# DEMETRIOU

July 31, 2017

**RE: ADU17-003, CAO1-005, DEV17-009, SHL1-007, SUB17-004 First Review Letter  
Land Use Applications for proposed home, ADU, driveway and retaining wall  
construction within a steep slope along the shoreline for the Lady Bug Trust**

NORTH
TREE REMOVAL PLAN
 SCALE: 1" = 10'-0"

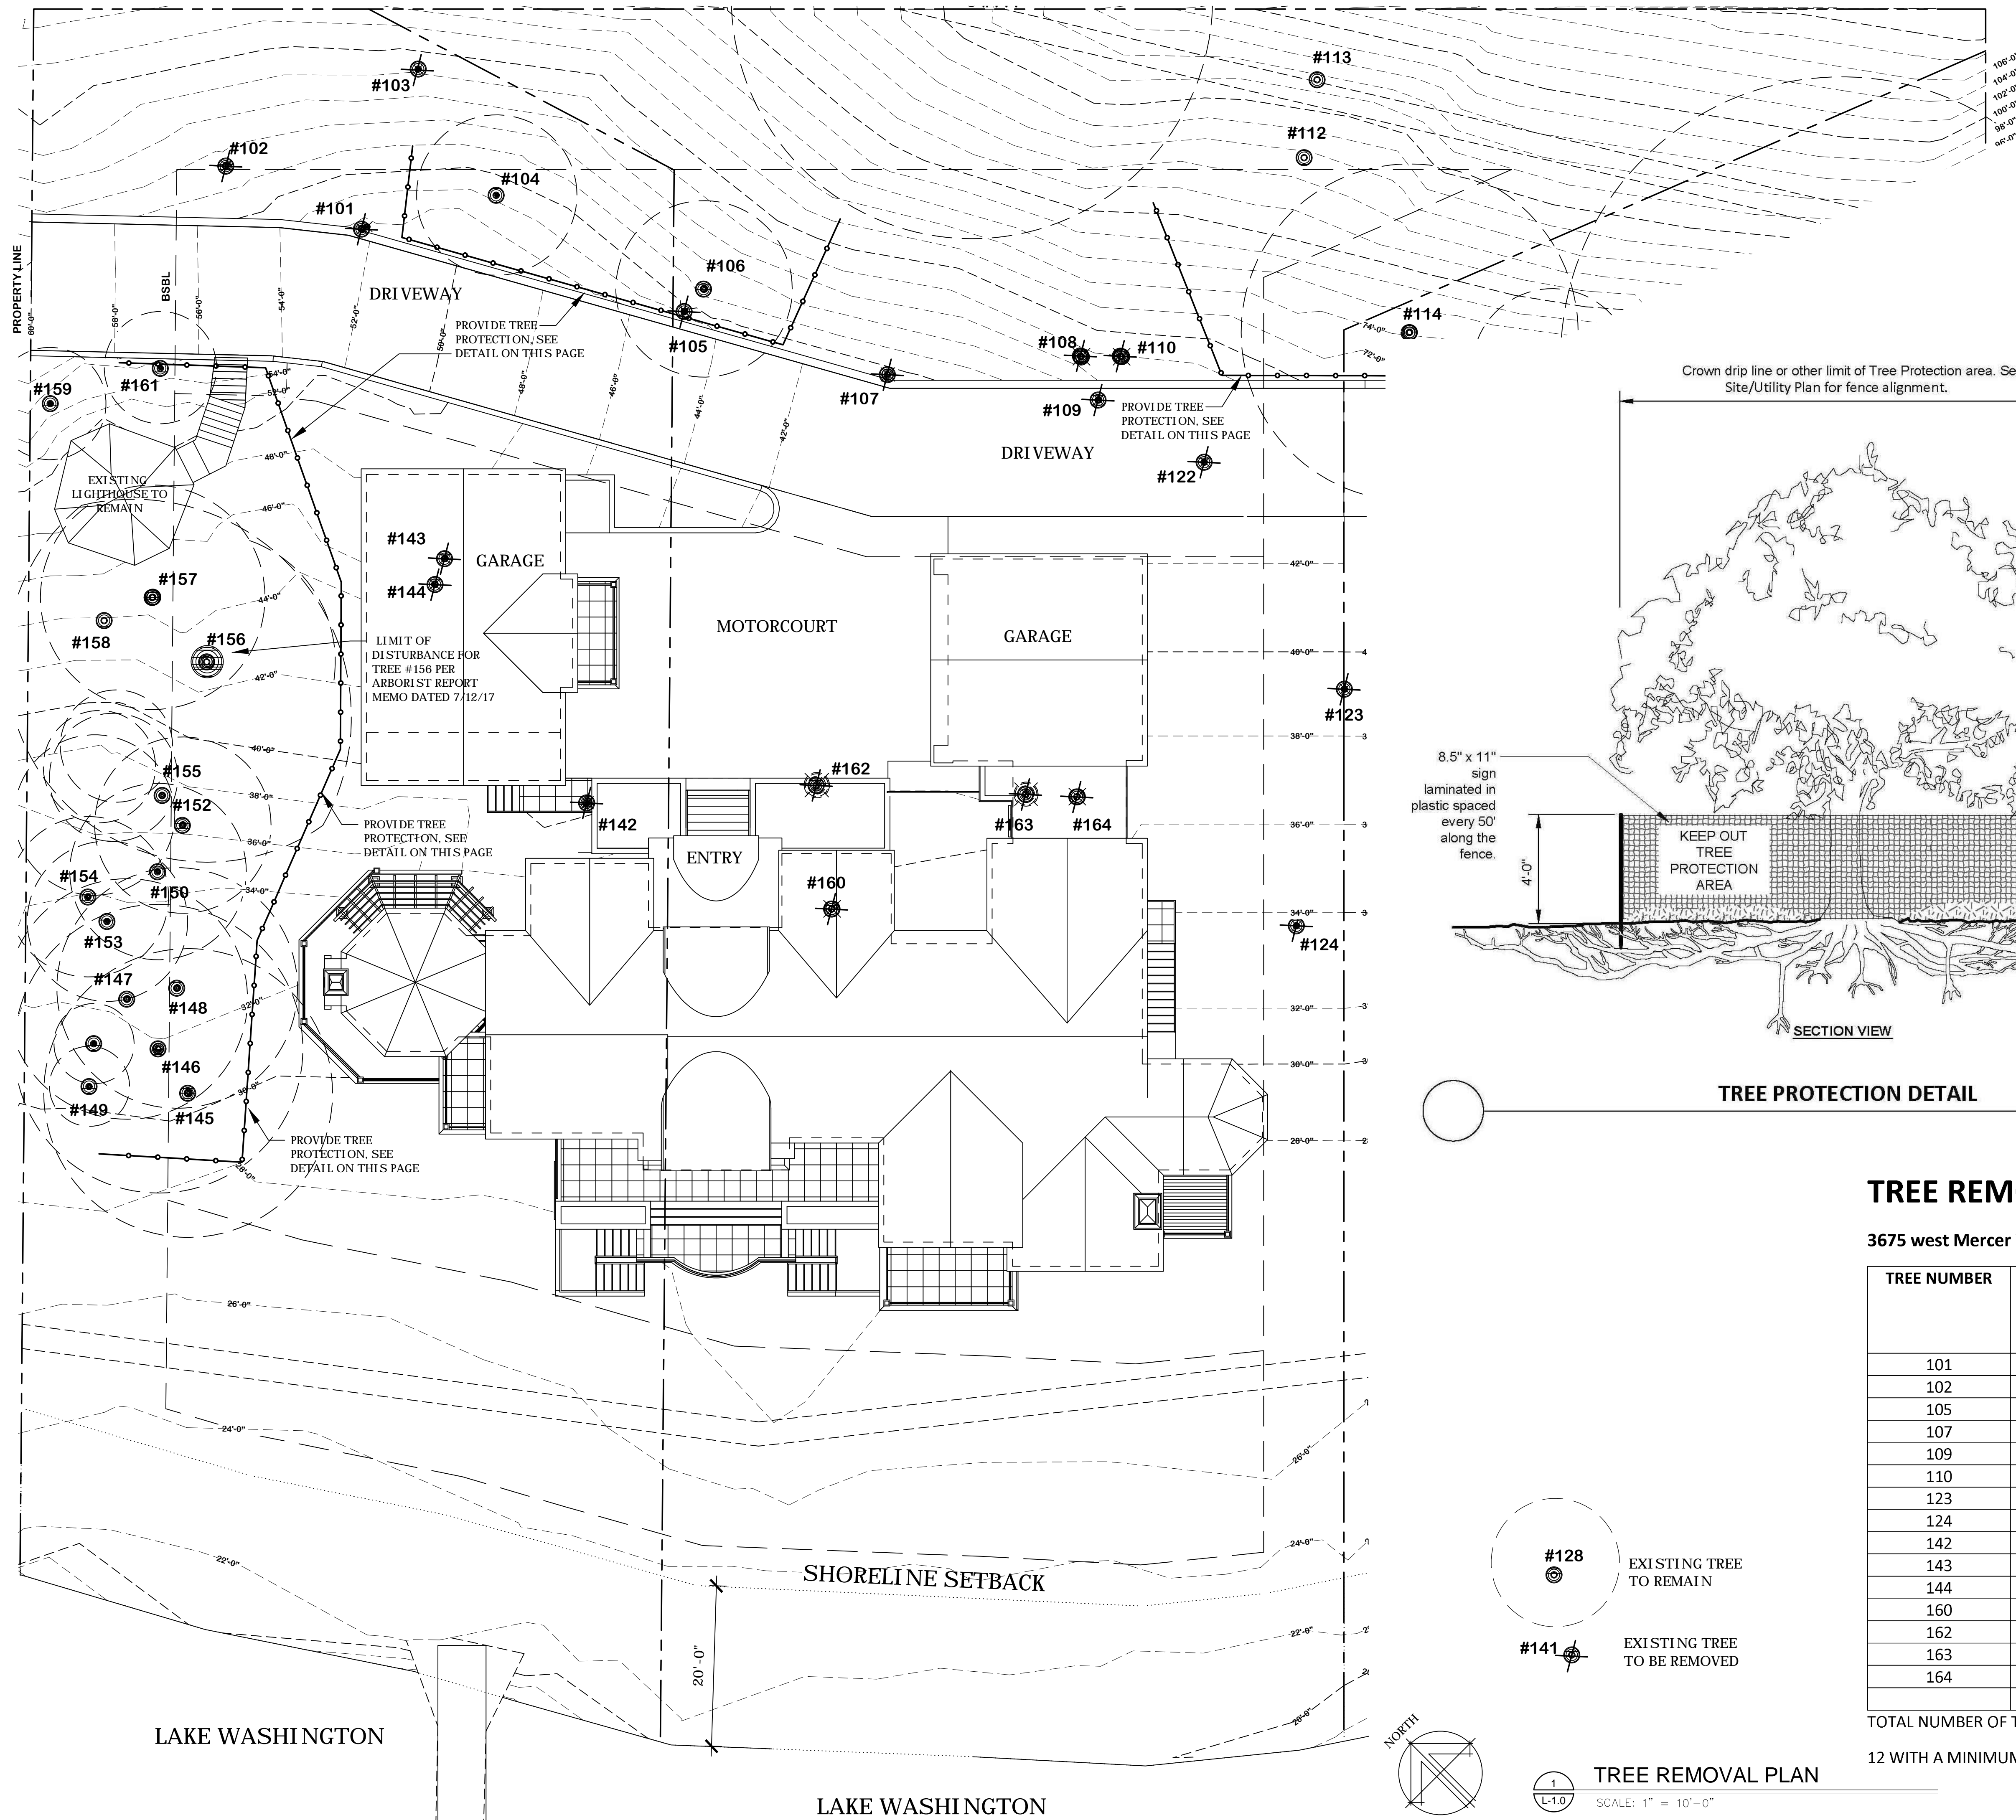
13. *Please provide two separate plans: one for tree removal and one for tree replanting plan.*

14. *Please retain tree 156 located on the western portion of Lot 1, and please note that there shall be no development inside limits of disturbance given by Project Arborist. We suggest conducting further analysis like air excavation to finalize these limits. Please show tree protection for tree 156 and other saved trees.*

**Please see L-1.0 for the Tree Removal Plan and L-2.0 for the Tree Replacement Plan.**

**Tree 156 will be retained. Please see the Arborist's memo dated 07/12/2017 that states the new limits of disturbance.**
